**Town and Country Planning Act 1990
Application for Permission to Develop Land**

Response from Pollution & Noise Control

PNC Reference No:	WK/201824260
Name of Planning Officer dealing with the matter:	Sarah Longbottom
Application Number:	2018/93906
Proposed Development:	Demolition of barn/workshop and erection of detached dwelling with attached garage
Location:	4-5 Mazebrook, Drub, Cleckheaton, BD19 4BT
Date Required By Planning:	01/01/2019

Title Proposed Site Layout							
Client Mr & Mrs T. Skirrow							
MWA Project Ref 6198	Scale 1:200	Original Paper Size @ A1	Paper Orientation Landscape	Drawn MW(J)	Checked		
File Identifier Project	Originator	Volume	Level	Type	Role	Number	Revision
TSDL - MWA - 01 - GF - DR - A - 0005 B

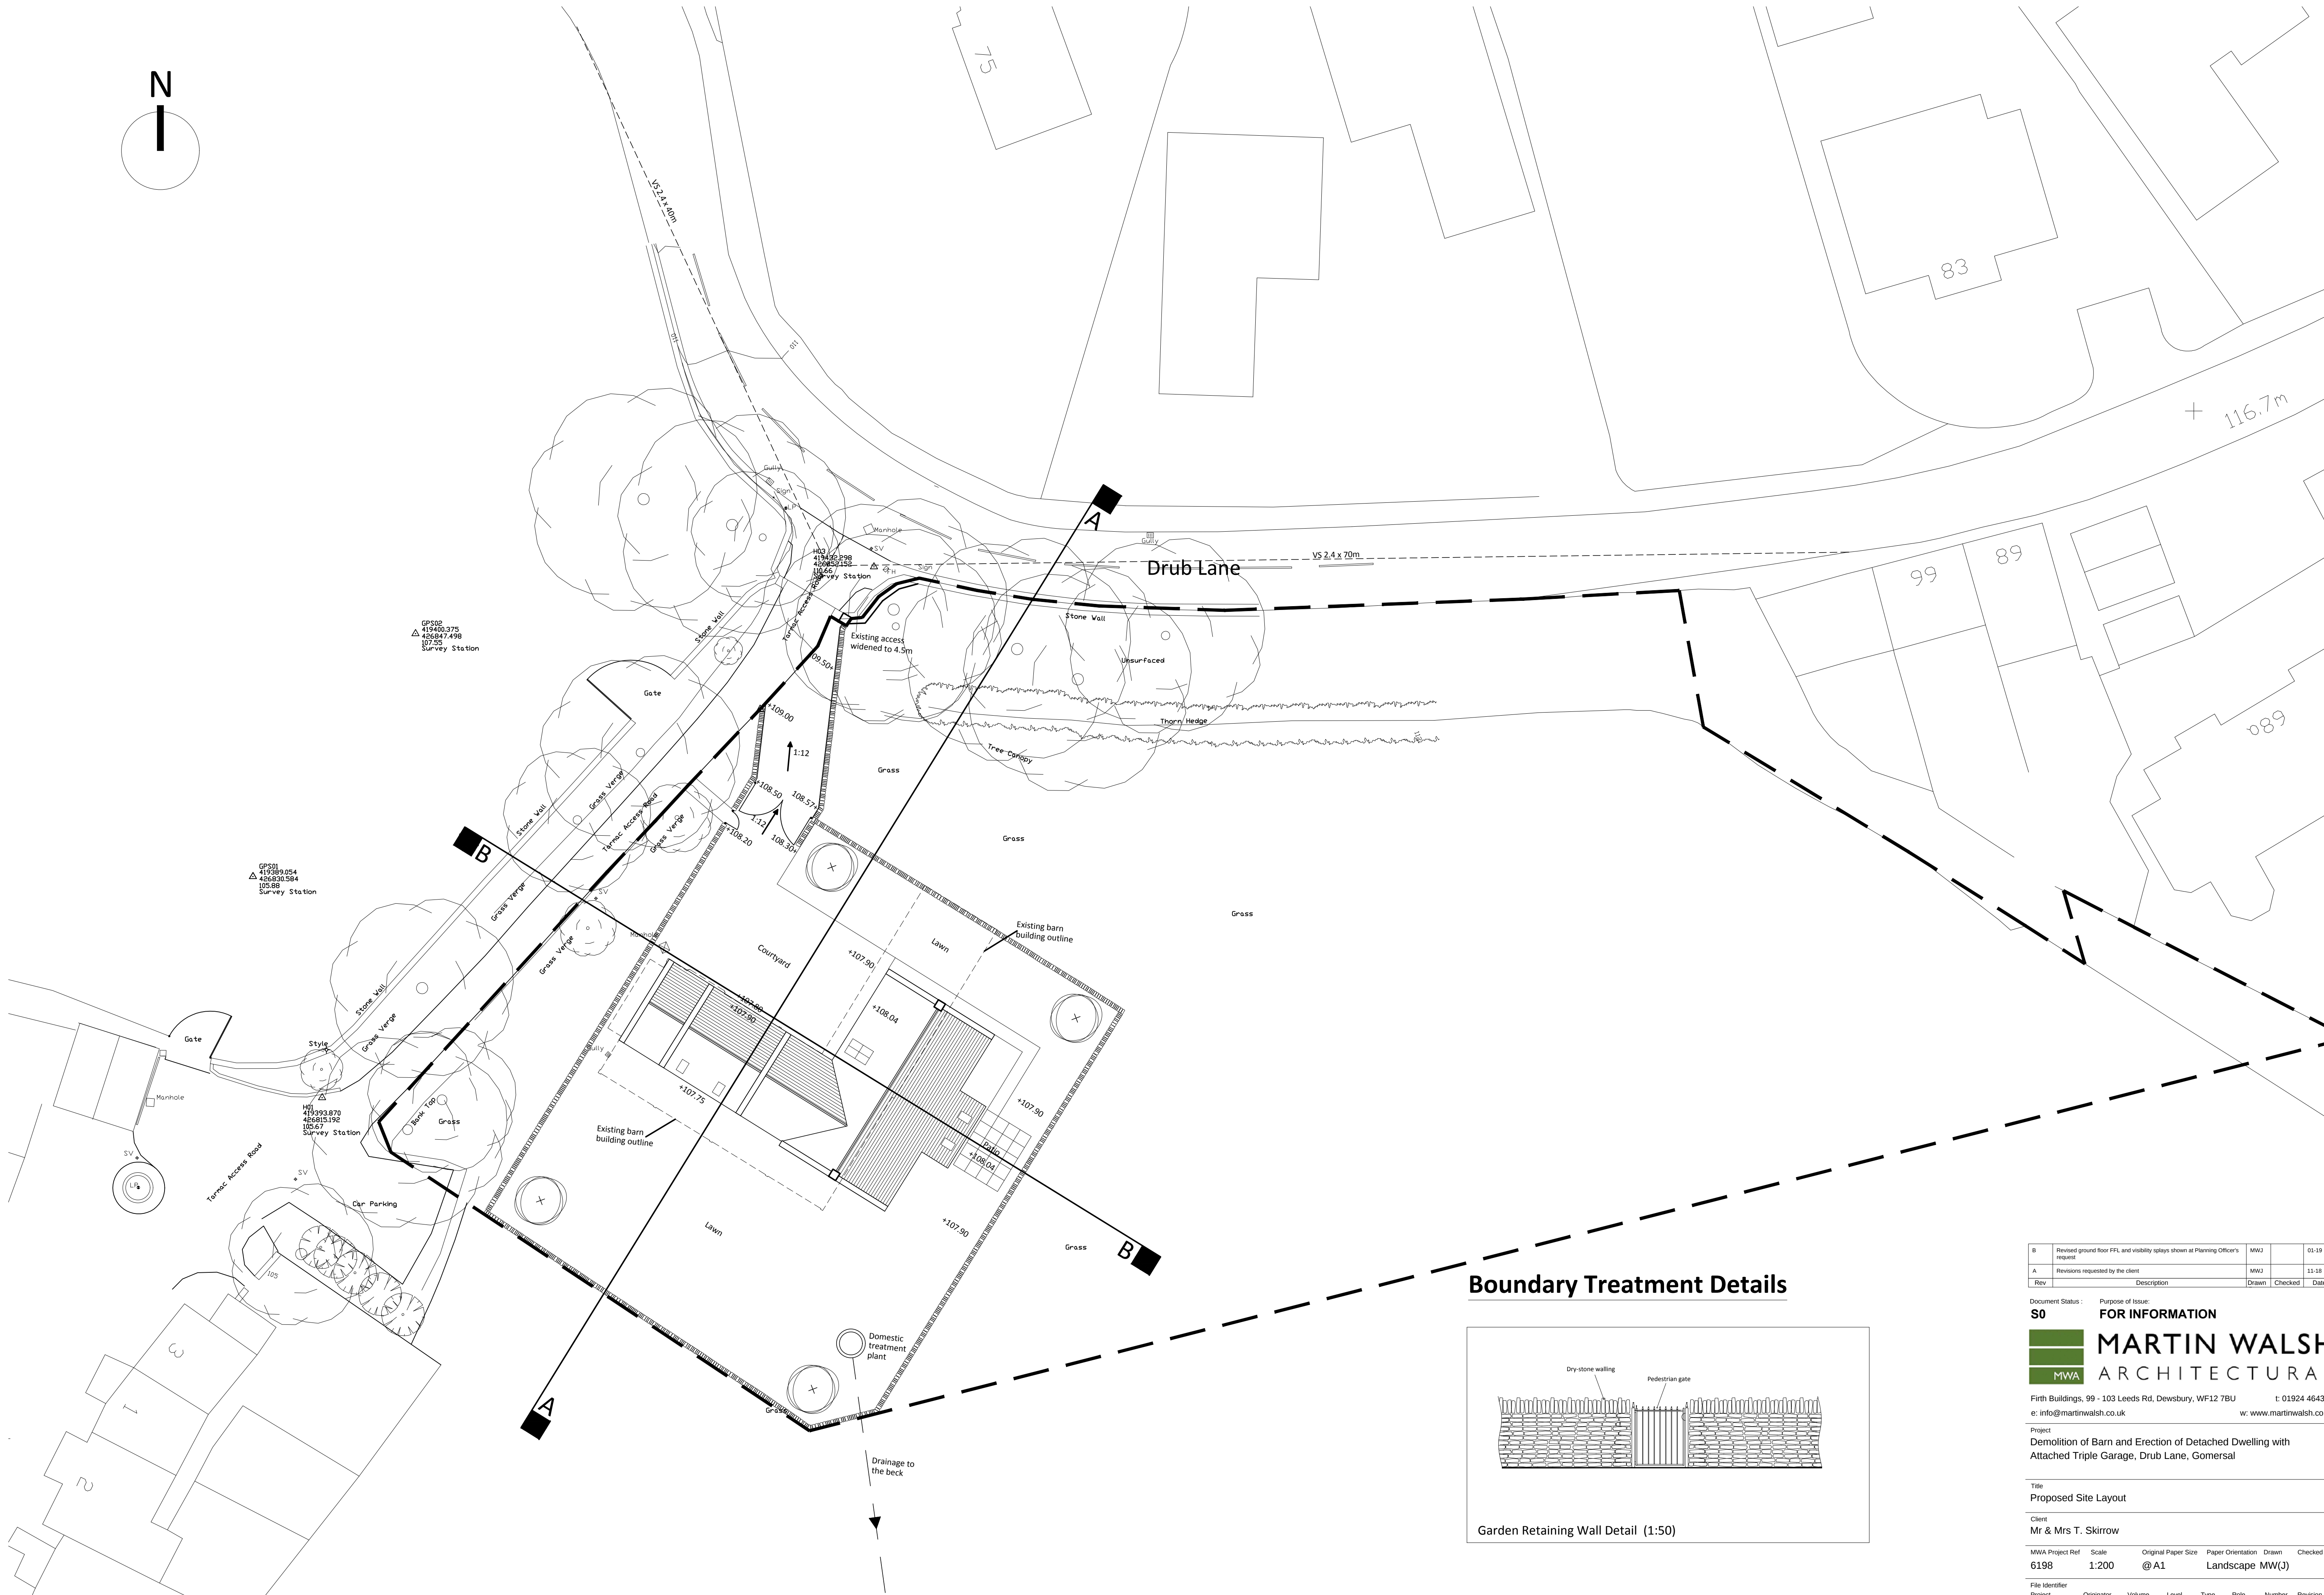
The application and Drawing number TSDL-MWA-01-GF-DR-A-0005A details a Package Treatment Plant as providing waste water treatment at the proposed development. I am aware that the proposed development is located within 90m of a Yorkshire Water Combined Sewer at Drub Lane. The applicant has provided no rationale as to why the proposed development cannot be connect to mains sewerage. I therefore recommend the following condition:

Before planning permission is granted I would recommend that the applicant submit a report giving details of the Package Treatment Plant to be installed. In particular the following information should be included:

- 1 A costed feasibility study for the connection to mains sewerage.
- 2 The capacity of the Packaged Treatment Plant and number of persons using the Plant.
- 4 Adequate means of vehicular access should be provided to allow for plant maintenance.
- 5 Details of where the outflow of the Packaged Treatment Plant is to discharge to. If the Plant is to discharge to a watercourse consent from the Environment Agency may be required. If it is planned to discharge to a soakaway or land drainage details of necessary porosity and percolation tests carried out to establish suitability of land.

It is important these tests are carried out before planning permission is granted. Failure to carry out the tests could result in permission for a development being granted when the land is incapable or not suitable for soakaway drainage. It is strongly recommended that no planning permission is granted for a development involving discharge of outflow to a soakaway or land drainage unless these tests have been carried out and the land found to be satisfactory.
